Department Ref: SSD-6334

APA Ref: 503132

RE: Submission on proposed Sutton Forest Quarry

Figure 2.1
 INDICATIVE QUARRY AREA LAYOUT

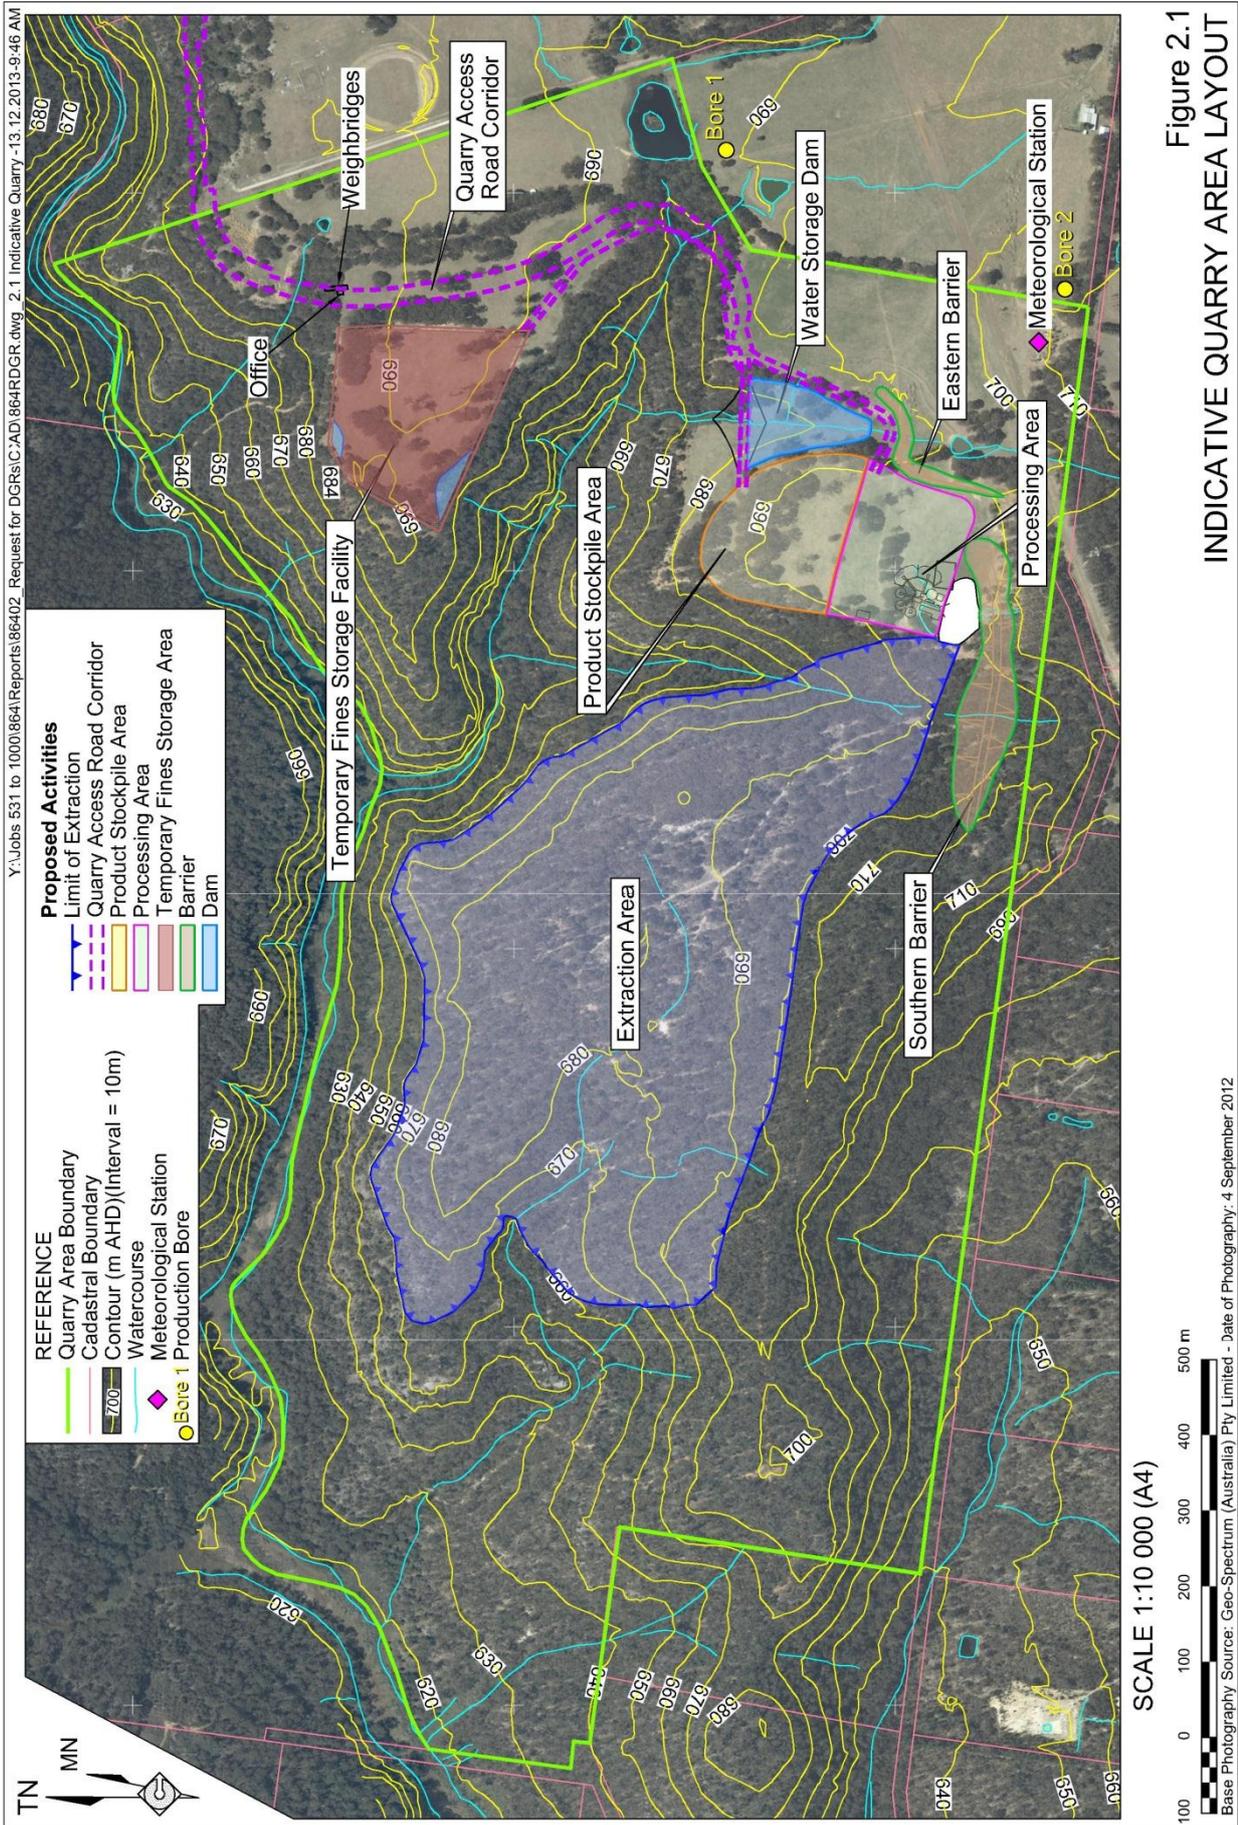
Figure 2.1 of the Environmental Impact Statement, Section 2, Description of Proposal, prepared by Sutton Forest Quarries identifies APA's infrastructure "high pressure gas transmission pipelines", located to the south east corner of the proposed site, directly south of proposed Eastern Barrier works.

The Project appears to involve crossings of APA's Moomba to Sydney Ethane Pipeline and Moomba to Wilton Pipeline. APA seeks to minimise the number of crossings and have these perpendicular to the pipeline if possible. This should include the co-location of road and services crossings. No work on the easement, including crossings, changes in ground level or other works, may occur without the prior authorisation of APA. Detailed design for crossings will need to be informed by field works to positively locate the pipeline (alignment and depth). Such field works must only be performed under APA permit.

Crossings of underground services must accord with APA requirements, particularly minimum separation distances. Road crossings for heavy vehicles (as expected to be required in this case) will require a concrete slab crossing to disperse loads on the pipeline to an acceptable level. This will need to be designed to APA requirements. Vehicular crossings during construction and operation will need be at the agreed crossing points.

Prior to the commencement of any works within the gas transmission pipeline easement, the proponent must seek a third party works authorisation from APA. Works within the gas transmission pipeline easement must comply with any conditions attached to a third party works approval. This includes both permanent roadway/driveway crossing, any sealed parking areas and any temporary crossing required during construction.

All plans which include the area of the gas pipeline easement must have the easement clearly identified with hatching on the full width of the easement. The easement must also be clearly labelled as *'high pressure gas pipeline easement – no works to occur without the prior authorisation of the pipeline operator'*.
